Re: 121-129 York St./Harborview Townhouses

**TO: CITY OF PORTLAND PLANNING AUTHORITY**  
**DATE: APRIL 14, 2011**  
**RE: REPLY TO LEVEL III SITE PLAN REVIEW COMMENTS DATED**  
**APRIL 12, 2011**

Subject: 127 – 129 York St.  
Owner Applicant: Harborview Development LLC

DRAWING: MEZZANINE/THIRD FLOOR

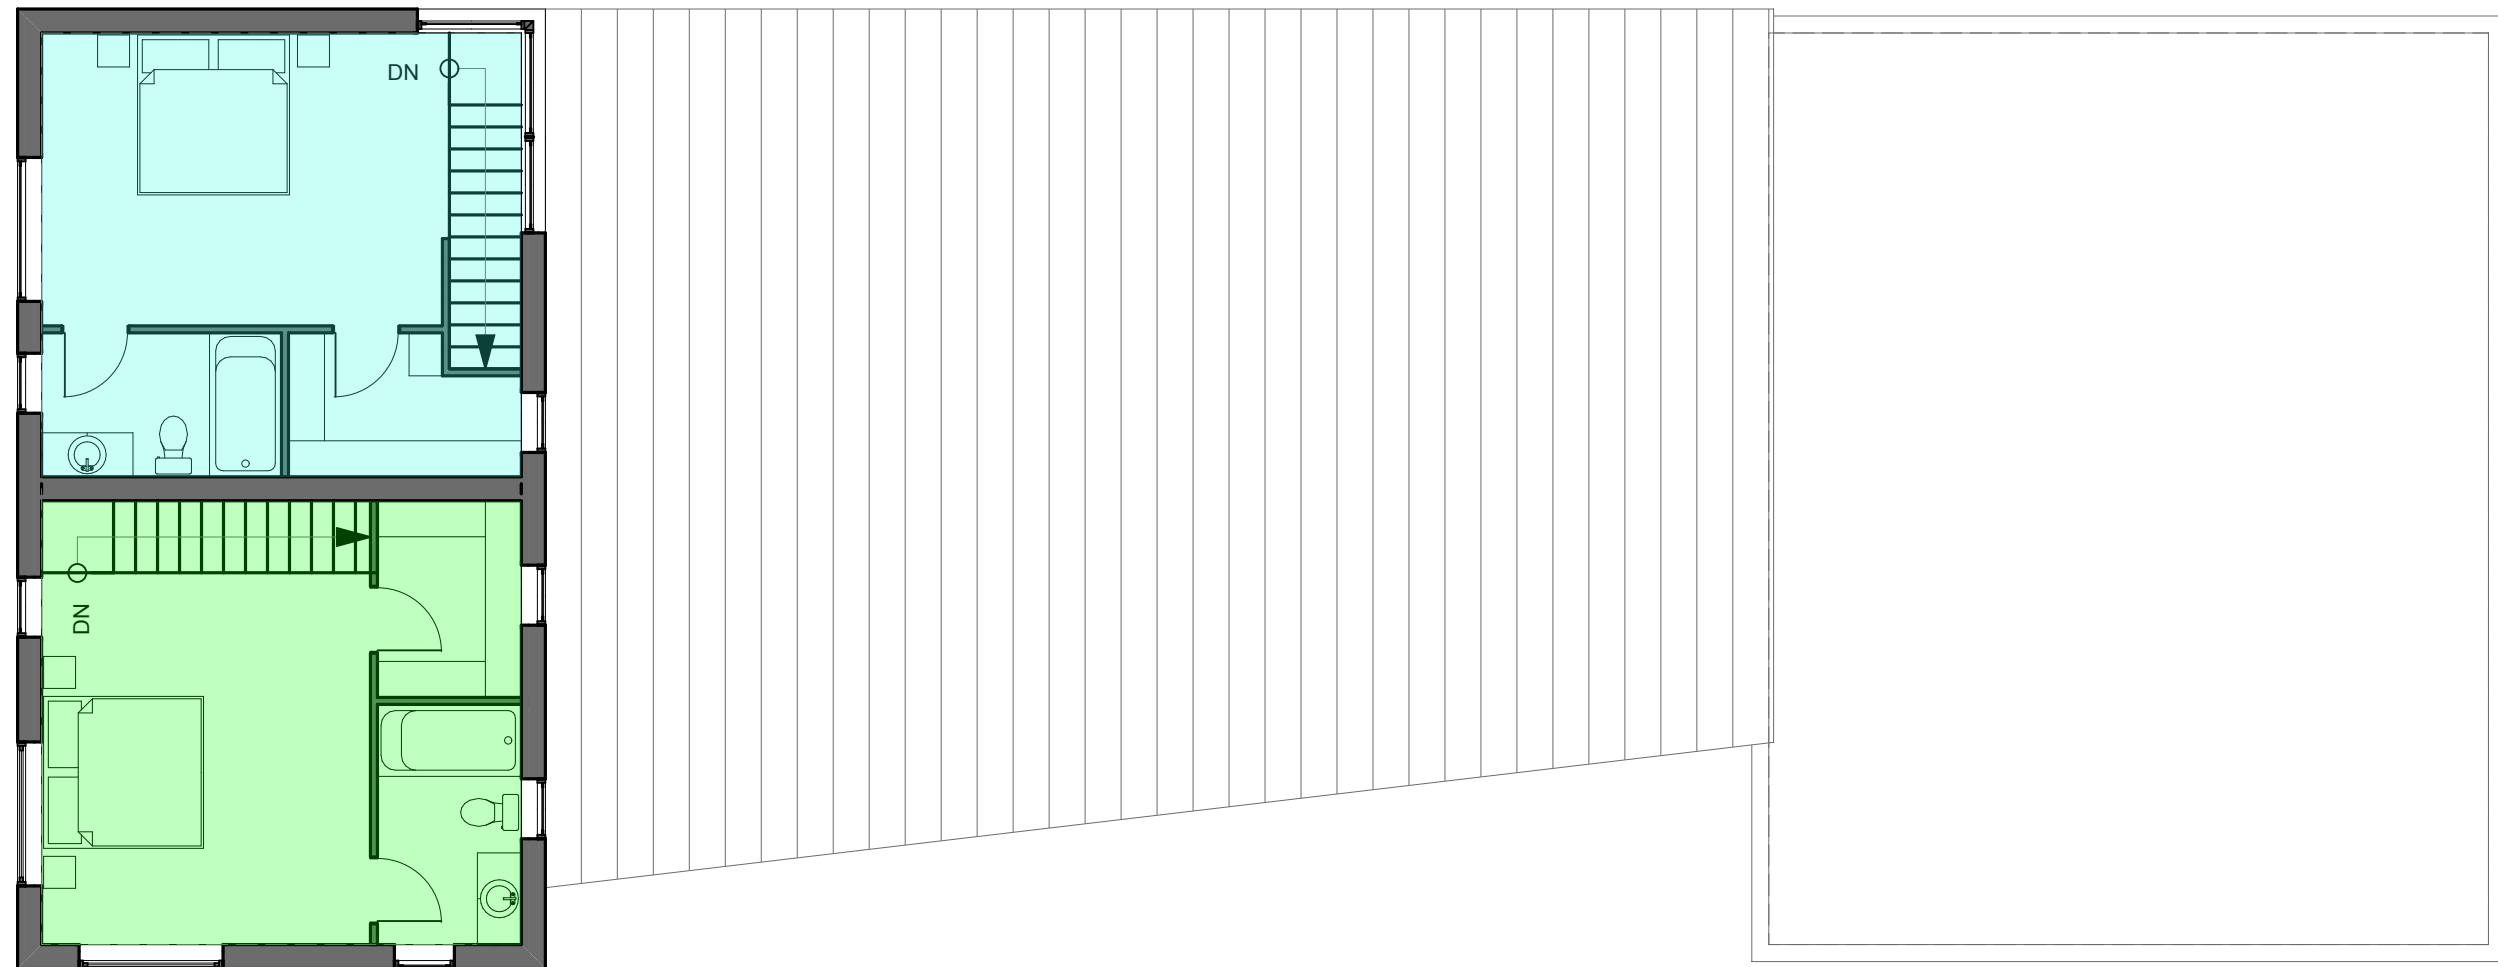
3. The building elevation sketches lead me to believe that the proposed building may be 4 stories and not three stories. I would need more information to analyze that compliance. If it turns out that this building is actually 4 stories, then the side setbacks are wrong on the plans. 12' instead of 10' would be required.

See again the attached, revised building elevation. The back two units have a mezzanine level between the second and third floor. As per 2009 IRC, Section R202 (p. 17), Definitions: Mezzanine, Loft. "An intermediate level or levels between the floor and ceiling an any story with an aggregate floor area of not more than one-third of the area of the room or space in which the level or levels are located."

DRAWING: SOUTHWEST ELEVATION

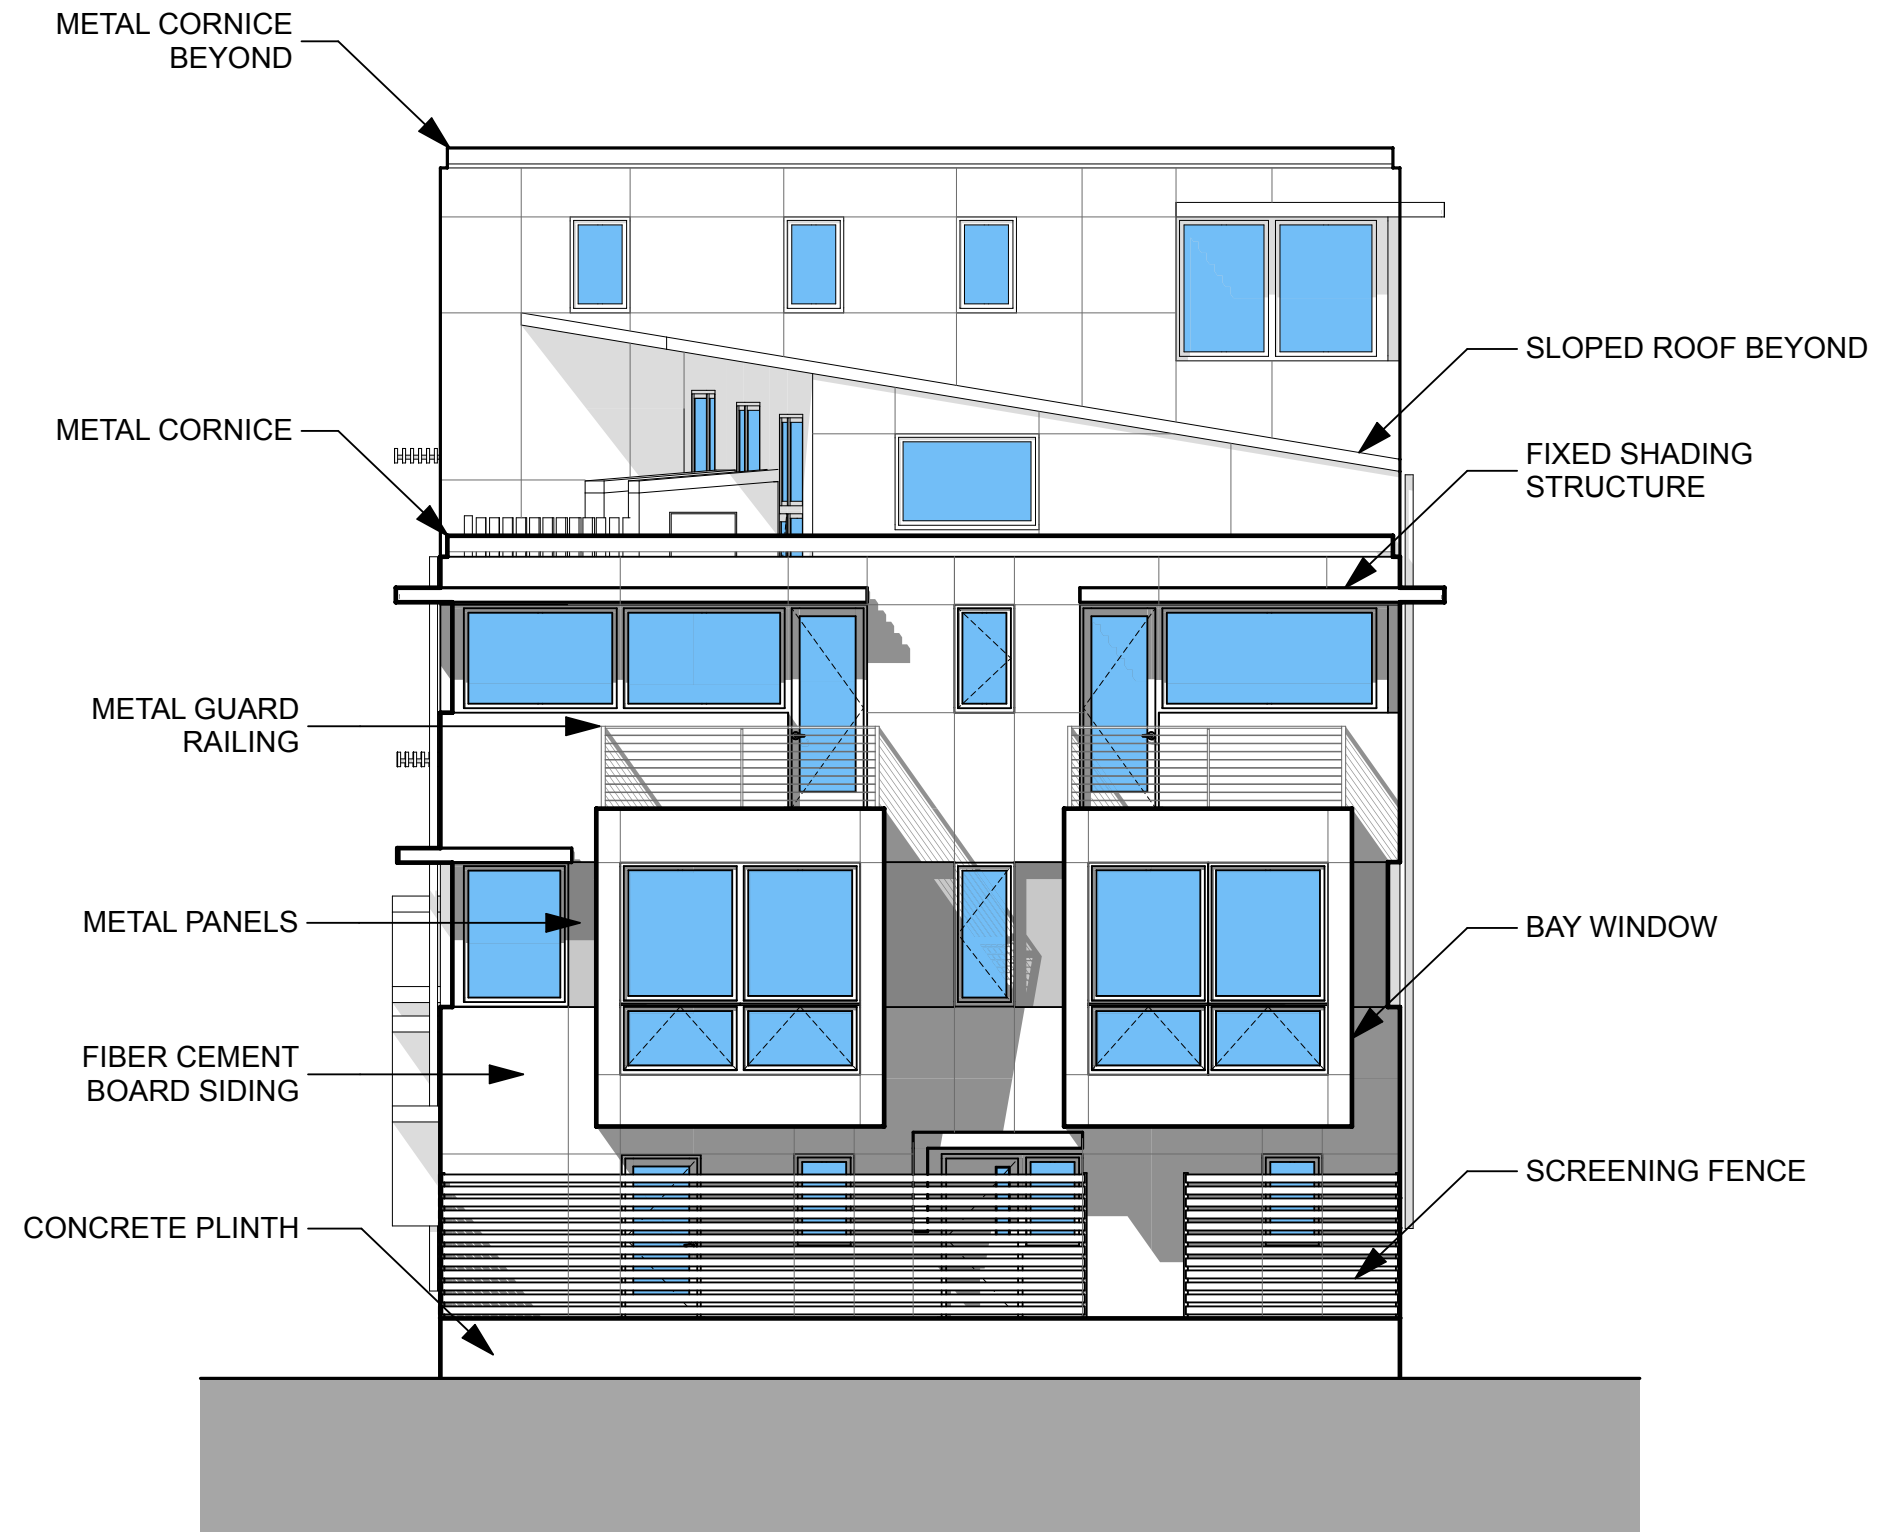
2. I was given the average grade, but I do not see the elevation of the top of the highest roof beam. Before I can determine the height of this building I would need to see that figure.

Please see the attached, revised building elevation. The roof beam at the tallest part of the building is 44'-6" above grade.
